Your Ref	SSD-10349252
Our Ref	NCA/11/2020
Contact	Atef Kazi
Telephone	9806 5061
Email	akazi@cityofparramatta.nsw.gov.au

COUNCIL SUBMISSION

NOTICE OF EXHIBITION OF RESPONSE TO SUBMISSIONS REPORT FOR PAEDIATRIC SERVICES BUILDING AT THE CHILDREN'S HOSPITAL AT WESTMEAD (CORNER OF HAWKESBURY ROAD AND HAINSWORTH STREET, WESTMEAD)

Scale	1 : 500@A1	Date	19/11/21
Drawn By	LL	Checked By	AF
Project No	19038	Revision	G
Drawing No	CHW-AR-DG-PSB-SSD011

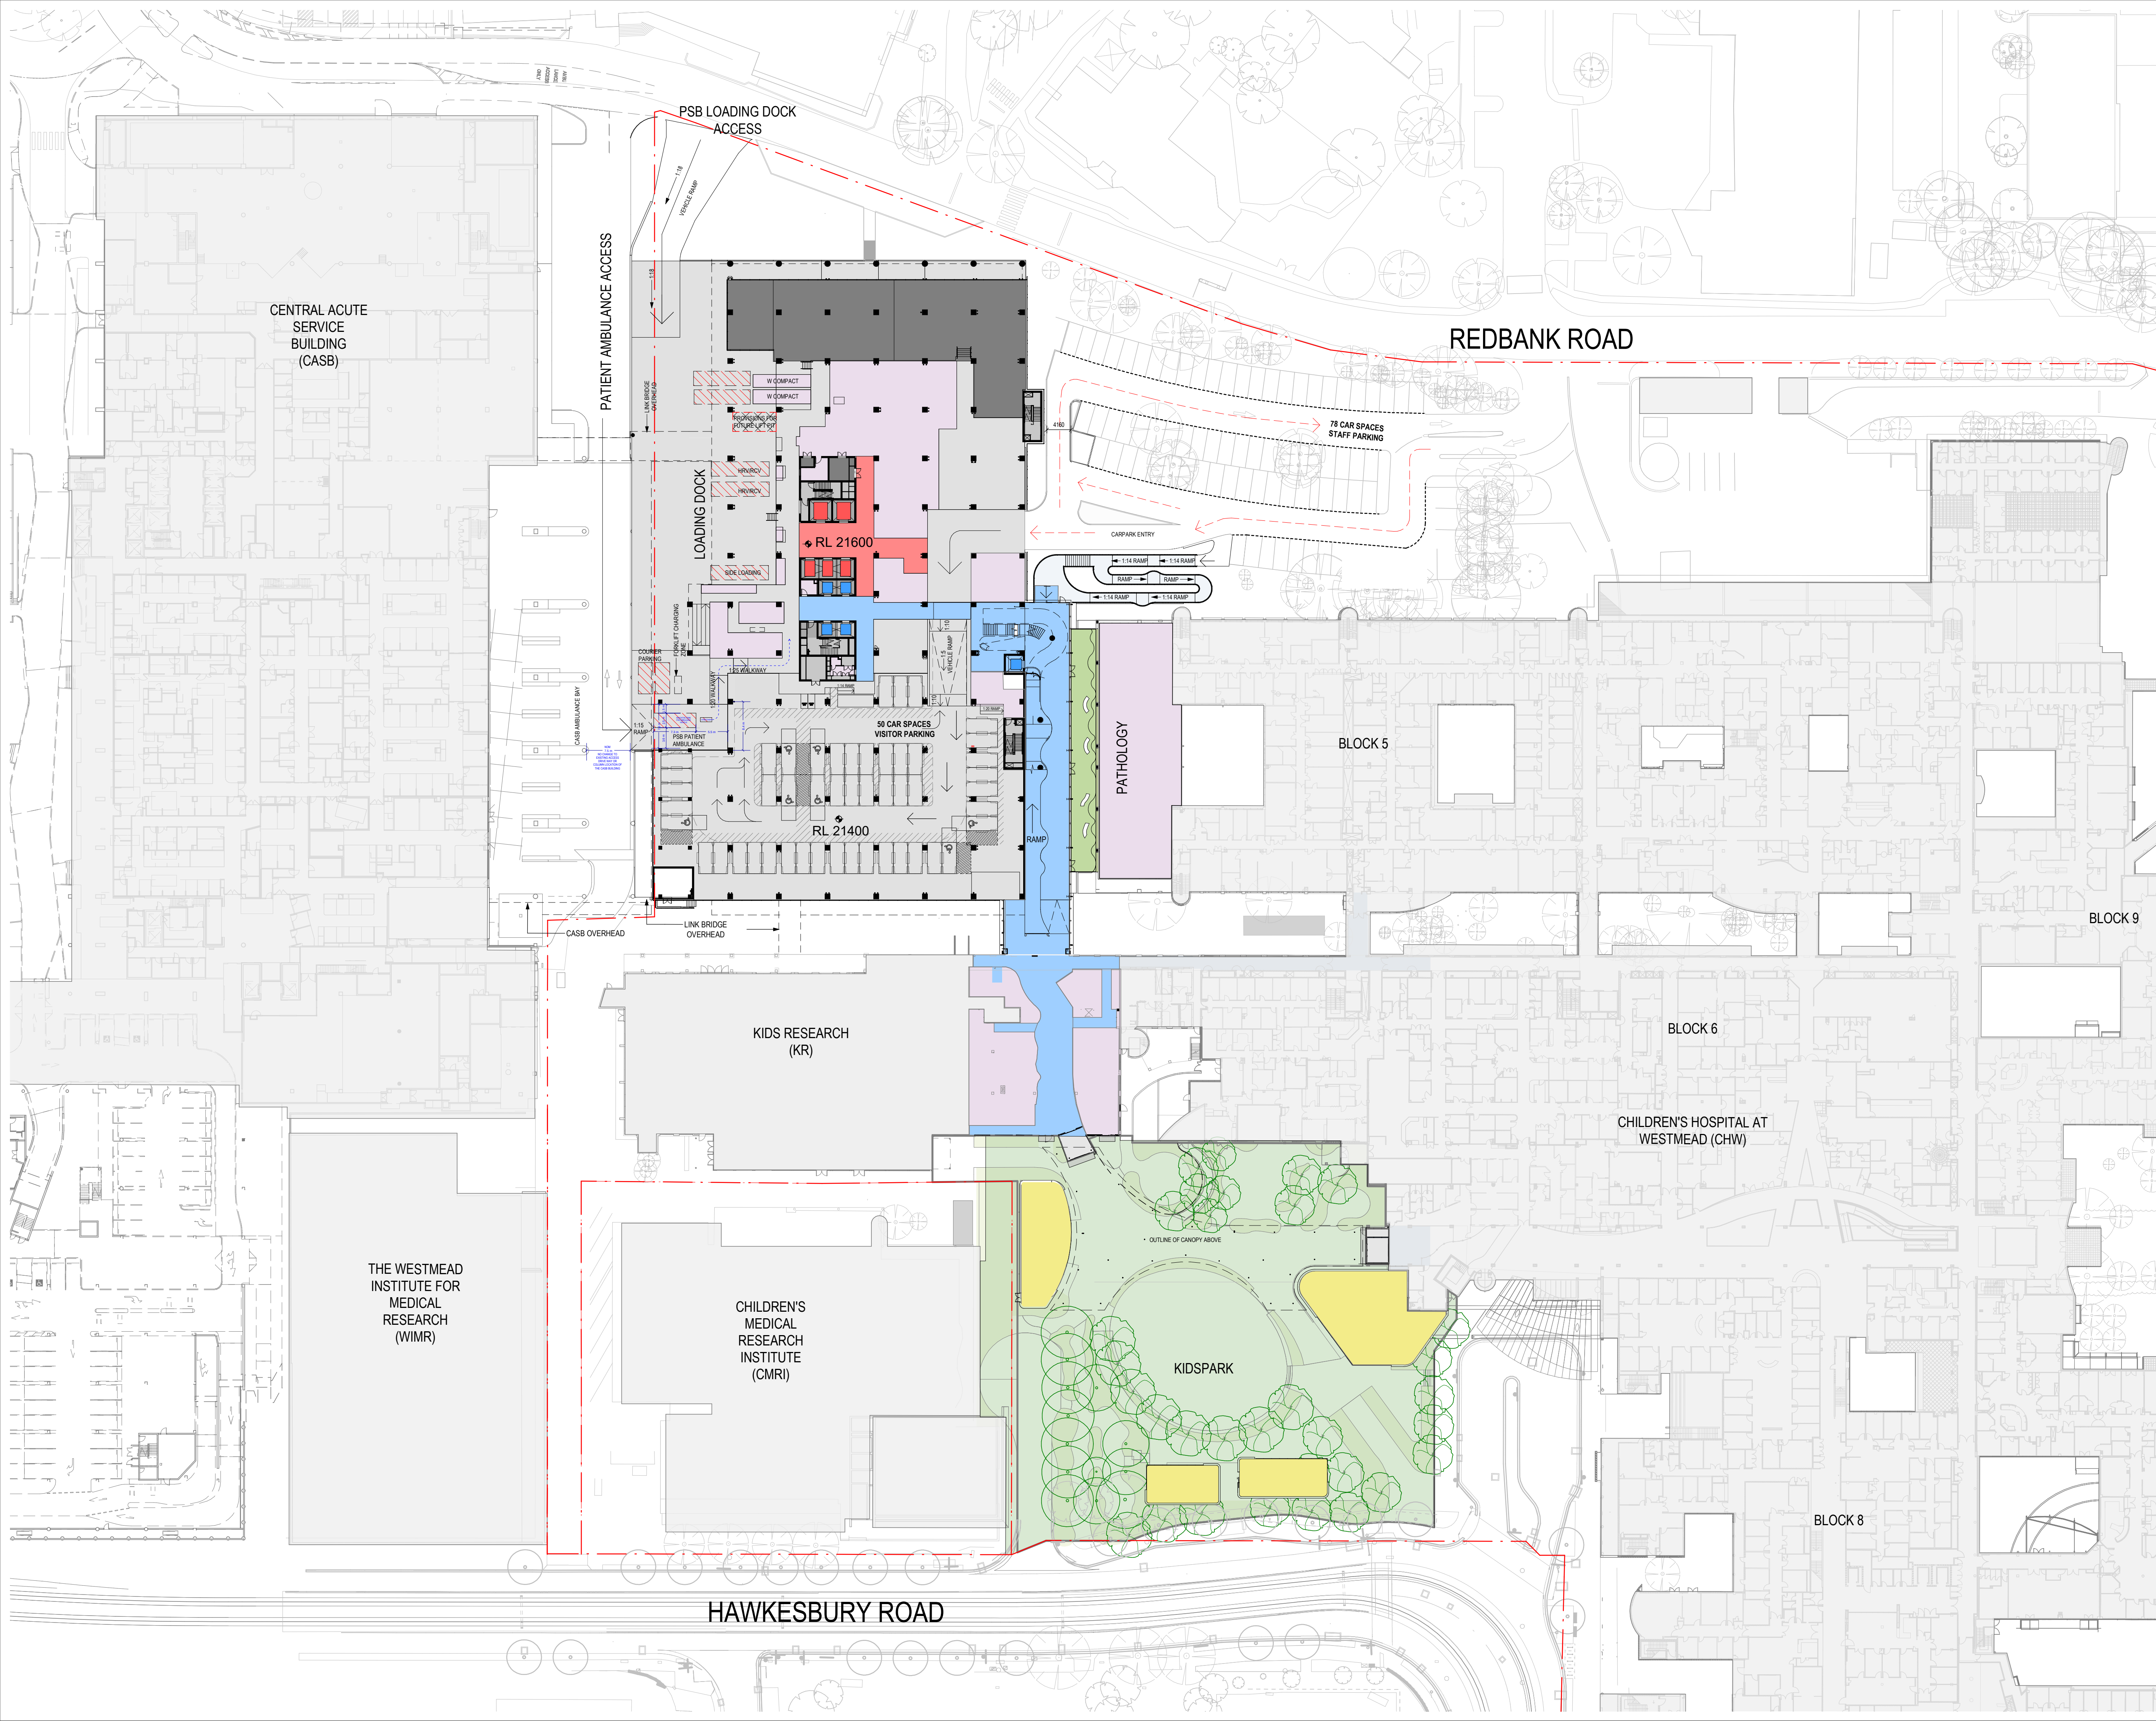
It is noted that the plans submitted (Dwg No. CHW-AR-DG-PSB-SSD011 Rev E) appears to show a concrete median proposed close to the cul-de-sac at the end of the driveway. It is recommended that the concrete median be removed to facilitate loading manoeuvres.

Based on the Level 02 plan (Dwg No, CHW-AR-DG-PSB-SSD011 Rev E), the ambulance bay appears to reduce to approx. 2.2m in width at the adjacent driveway entrance. This width is considered too narrow to accommodate an ambulance vehicle. Aerial images show that the width of the ambulance bay is approx. 3.4m with Keep Clear installed at this location. However, it appears there are no changes proposed to this ambulance bay as part of this development. It is recommended that the plans be amended to reflect the current site arrangements to ensure the bay can accommodate an ambulance vehicle.
